## **Suffolk County Council (20041323)**

Additional Evidence relating to the  
Landscape and Ecological Management Plan

## **Bramford to Twinstead (EN020002)**

Deadline 6

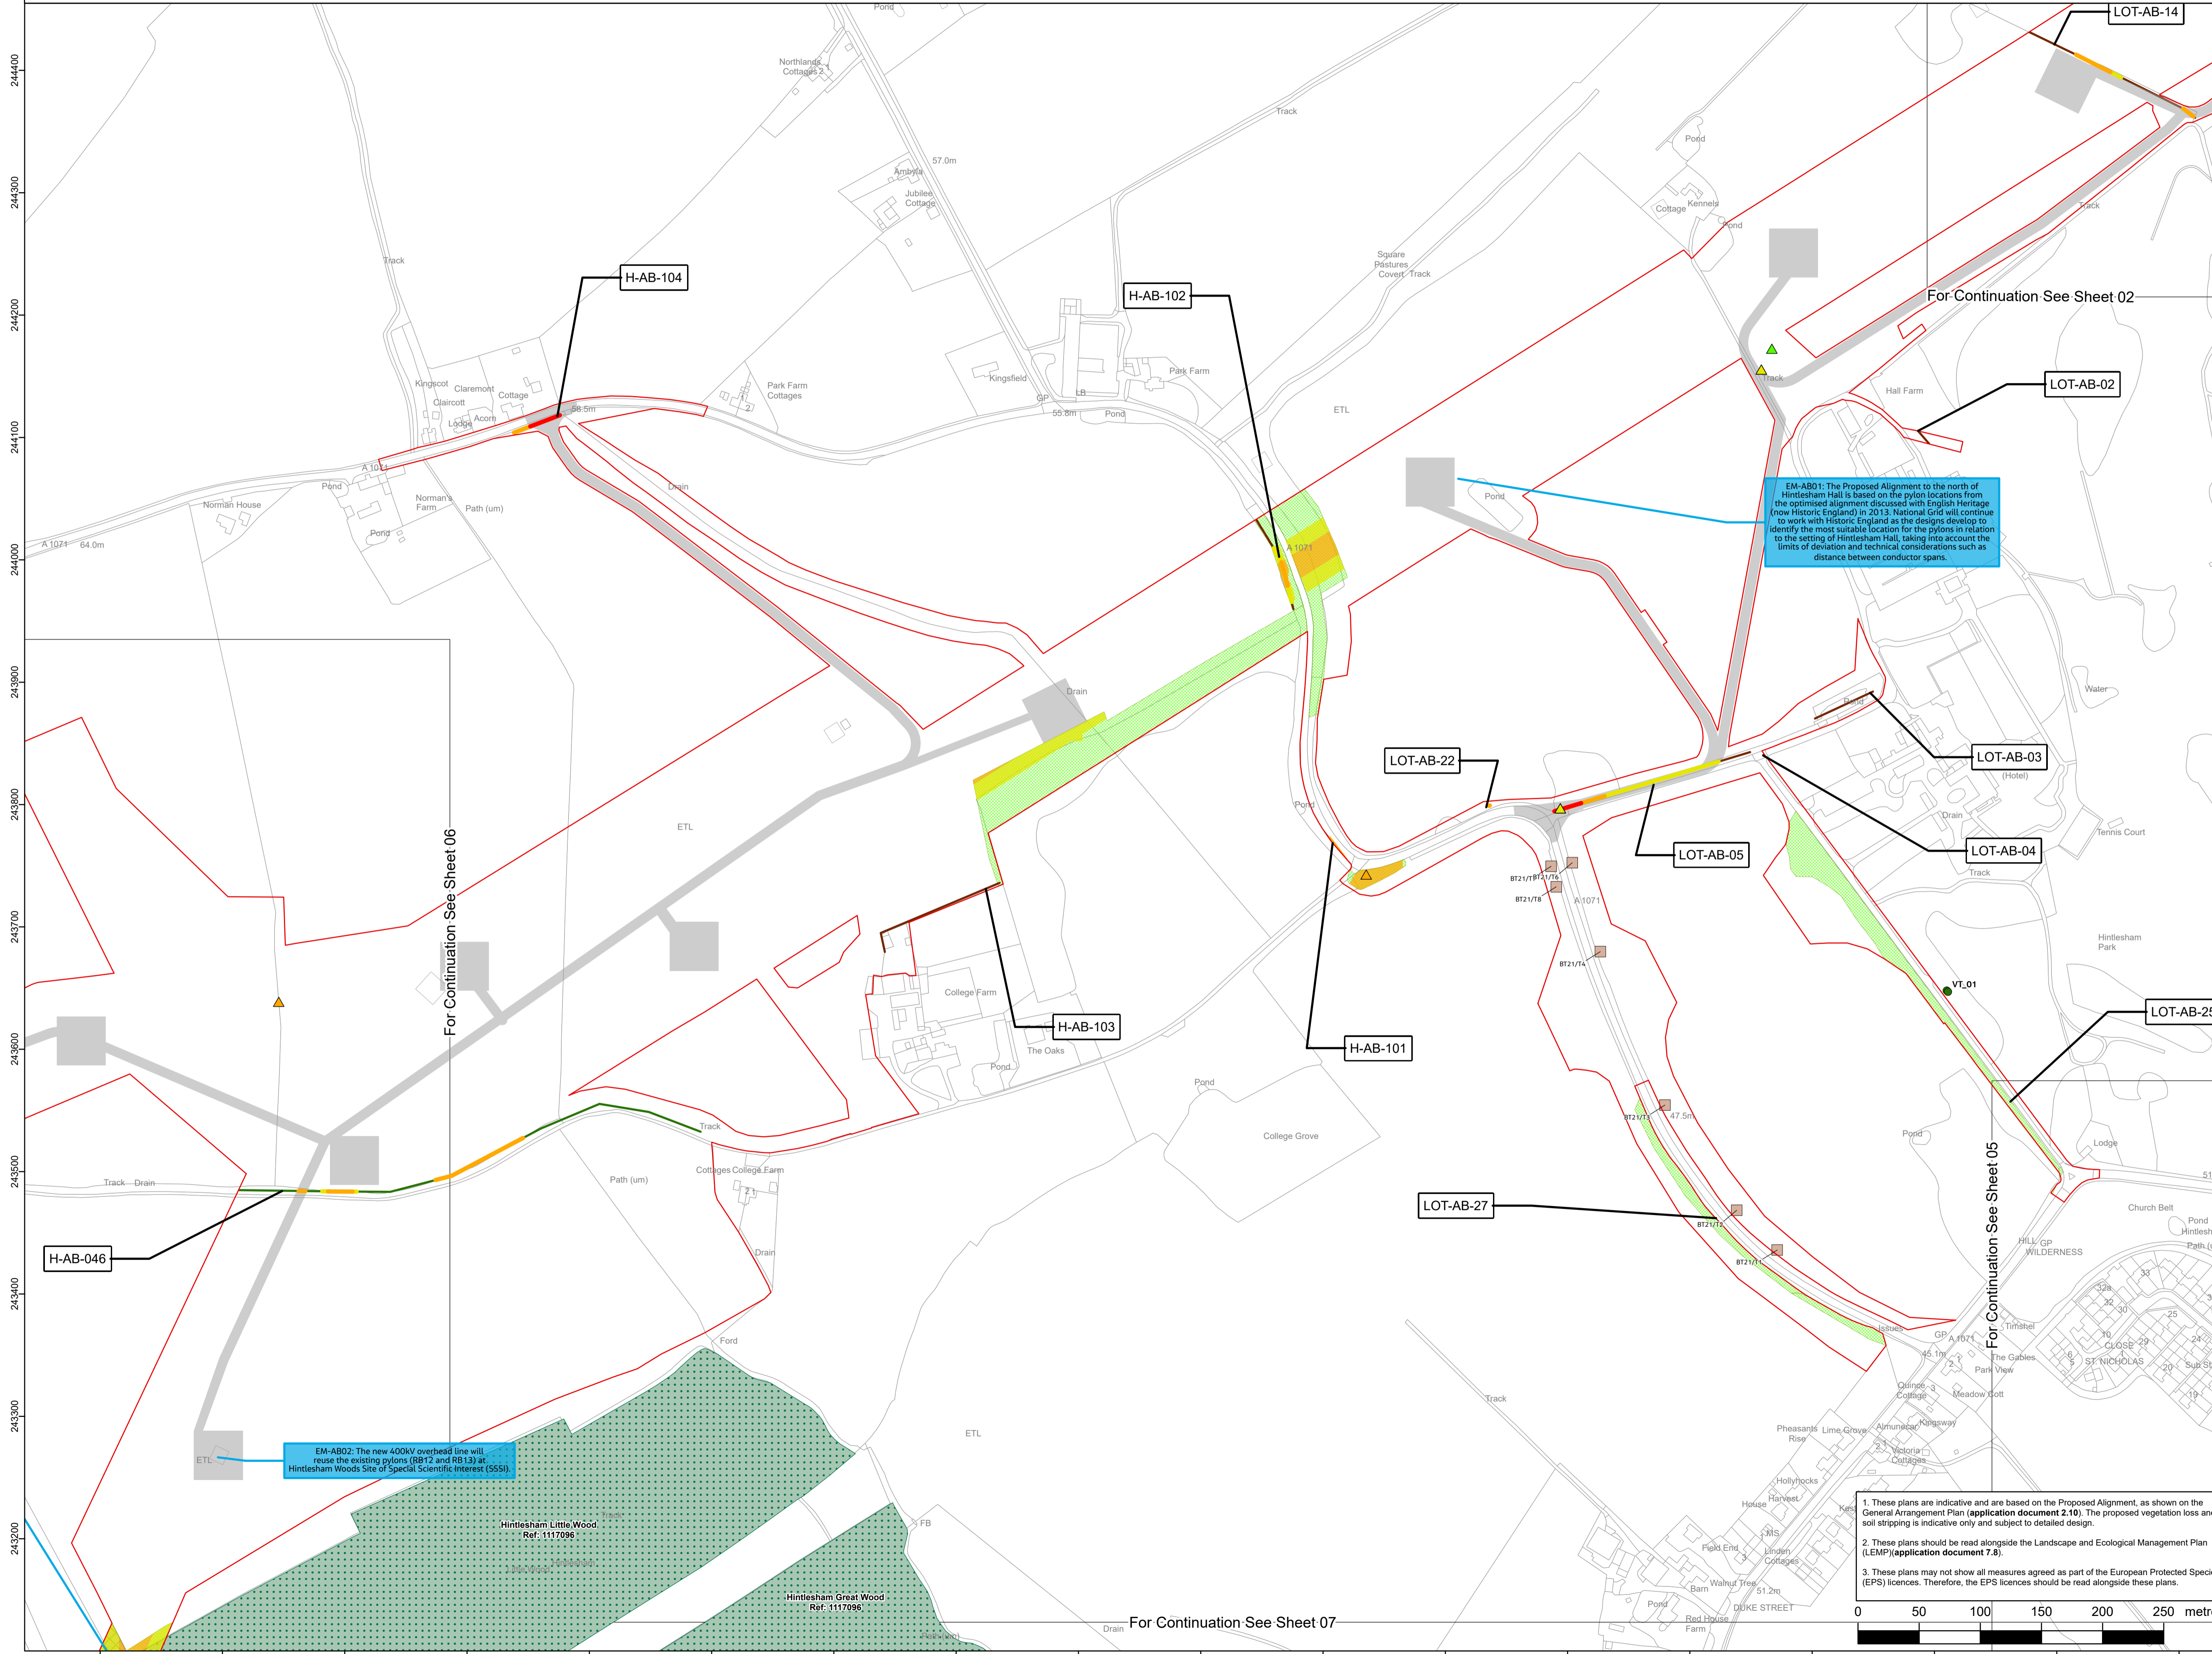
- 1.8.b At Hintlesham Golf Club the existing hedge at LOT-AB-14 (Sheet 03 Vegetation Retention and Removal Plan) should be strengthened and gapped up and then be continued south-eastwards on the eastern side of the exiting track to connect to the woodland.
